**WEST SUSSEX COUNTY COUNCIL  
PLANNING SERVICES CONSULTATION**

**SUBJECT: A/99/17/OUT - Outline application with some matters reserved (Access only) for development up to 175No. residential dwellings, public open space, play areas with associated infrastructure including roads, drainage & landscaping. This application affects the character & appearance of Angmering Conservation Area & the setting of Listed Buildings. This application is a Departure from the Development Plan.**

**Land South of, Water Lane, Angmering**

TITLE: PROPOSED IMPROVEMENT SCHEME TO A280 / A27 / TITNORE LANE ROUNDABOUT	
PROJECT: LAND SOUTH OF WATER LANE, ANGMERING	CLIENT: RYDON HOMES, GLEESON DEVELOPMENTS LTD

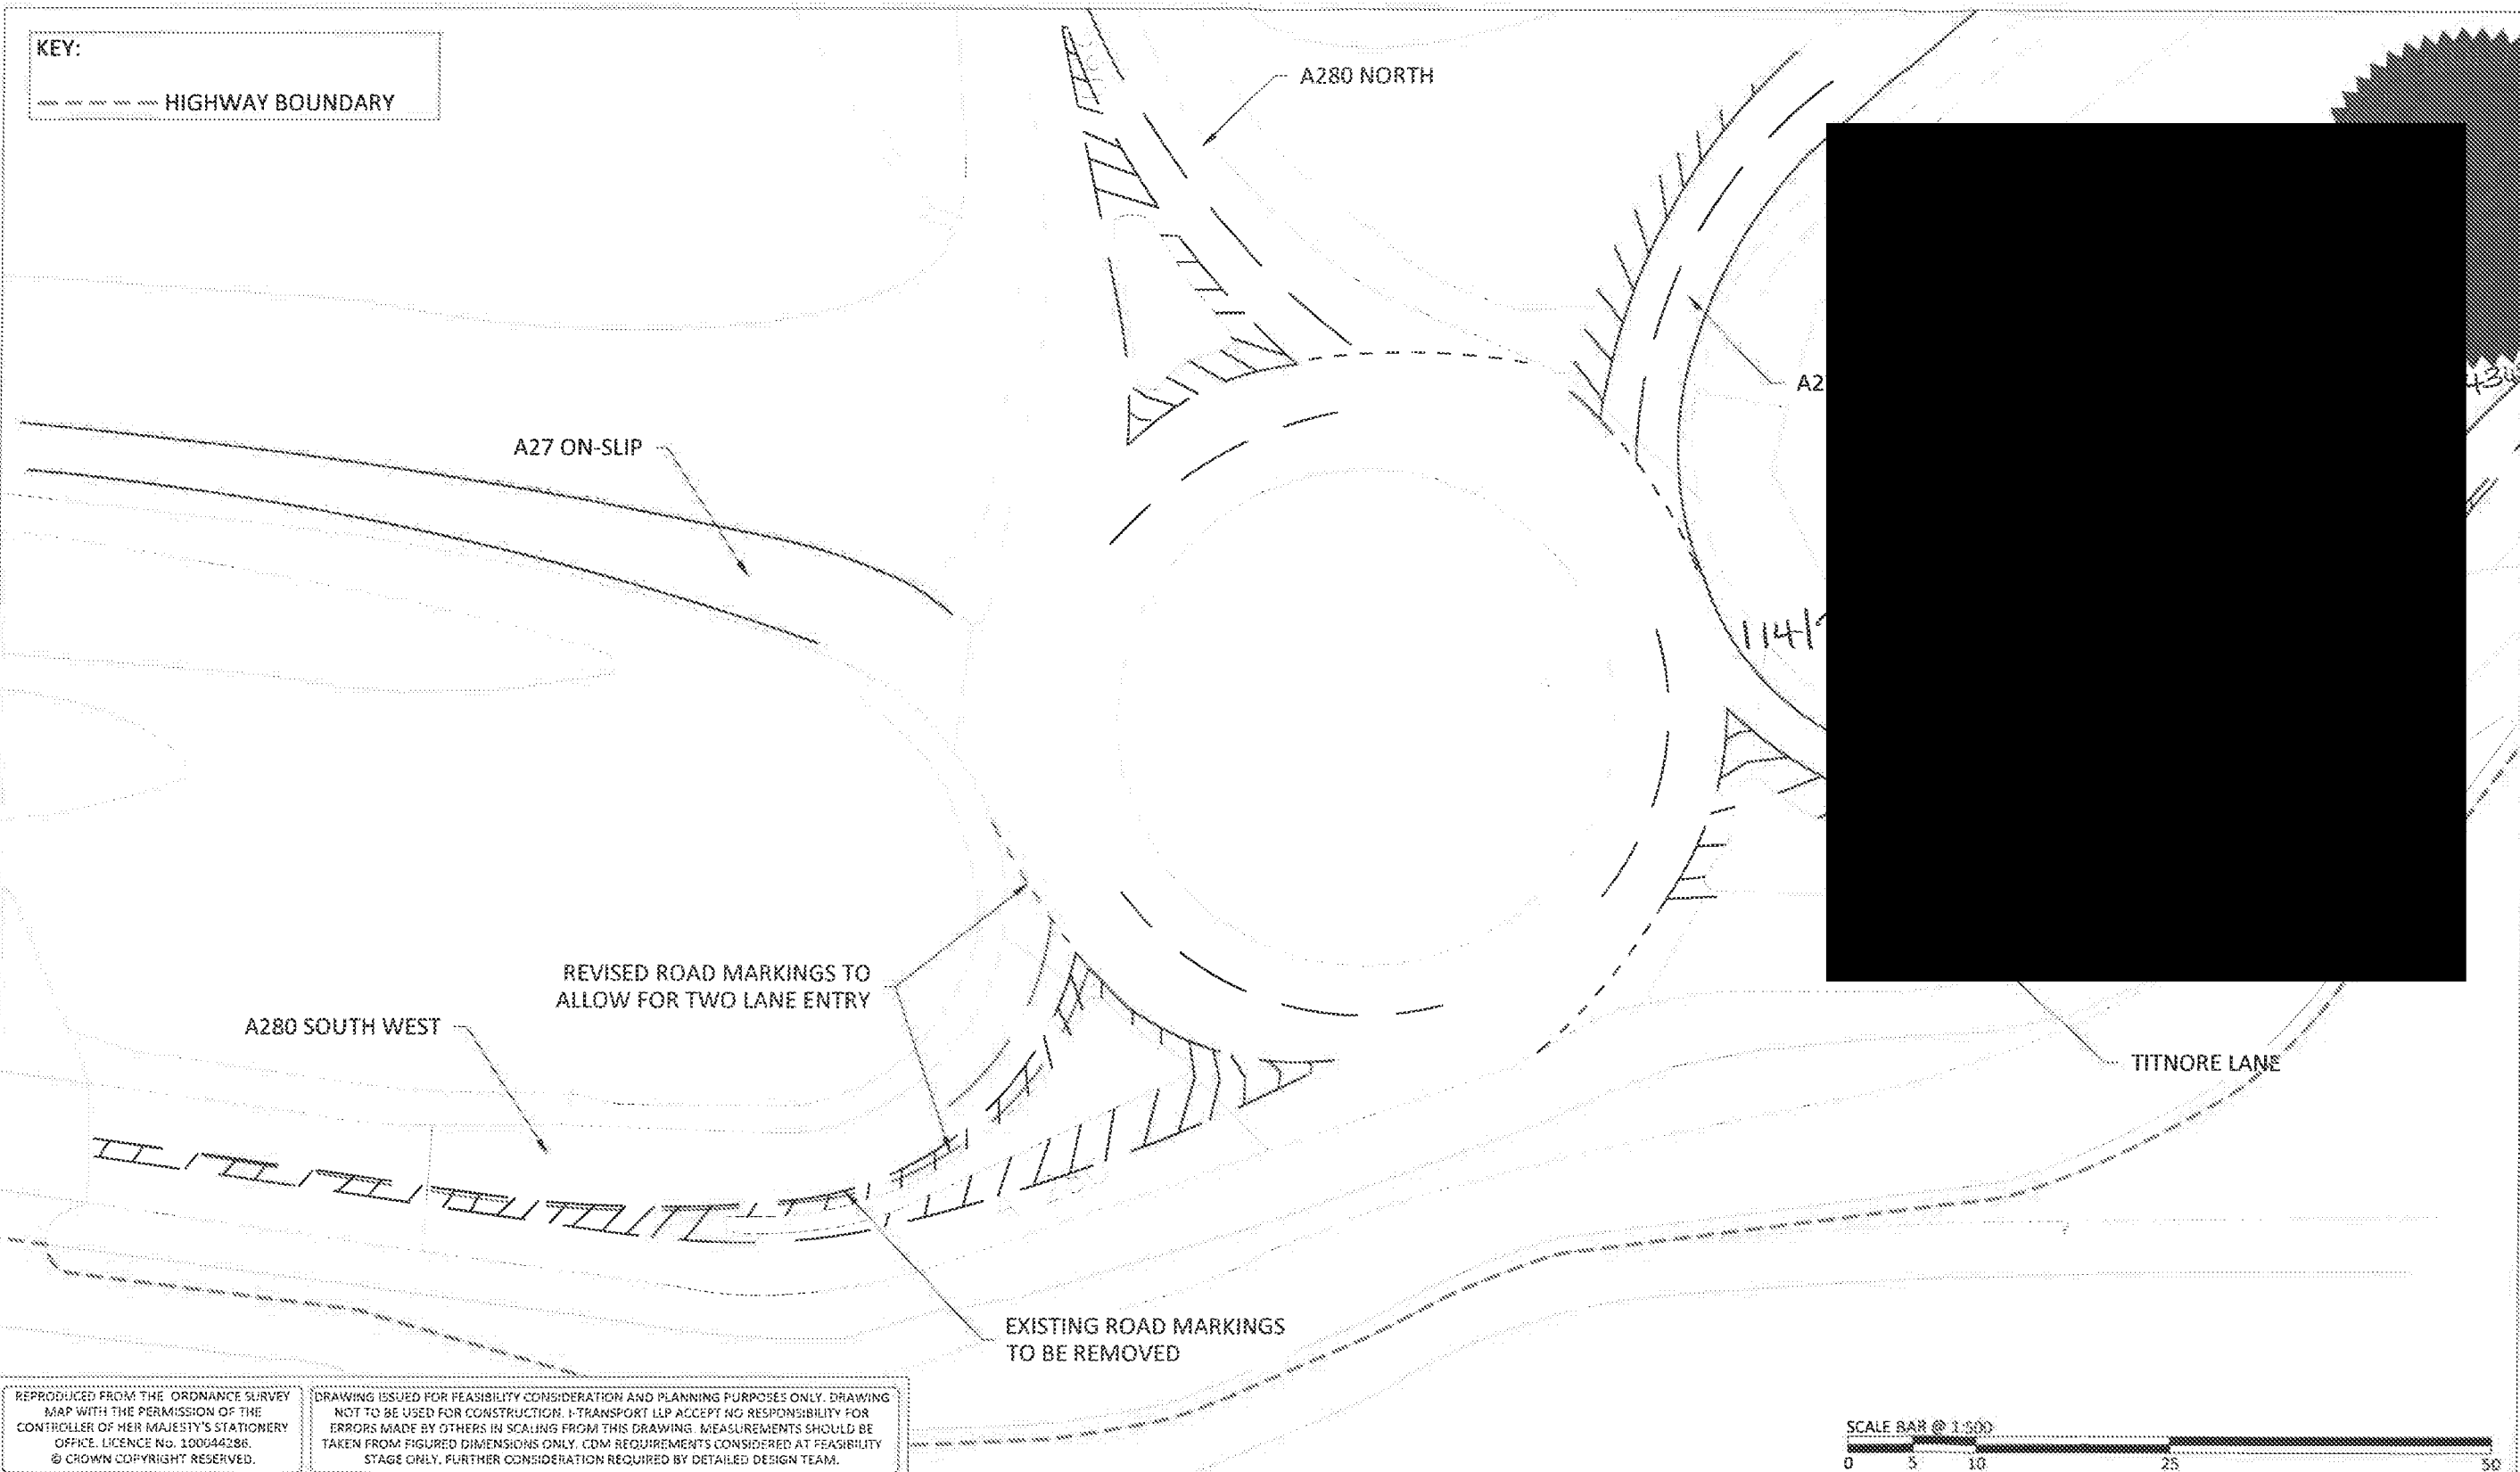
The modelling highlights that the junction is approaching capacity when development traffic is included on the A280 South West Arm. A mitigation scheme is proposed in which the two lane entry is extended via lining improvements on the existing carriageway.

- Highway works to A280 / Water Lane Signal Improvement (Drawing ITB9105-GA-021B)
- Highway works to A27 / A280 / Titnore Lane – Approach widening (Drawing ITB9105-GA-023)
- Highway works to Weavers Hill - Bus Stop Improvement (Drawing ITB9105-GA-026A)
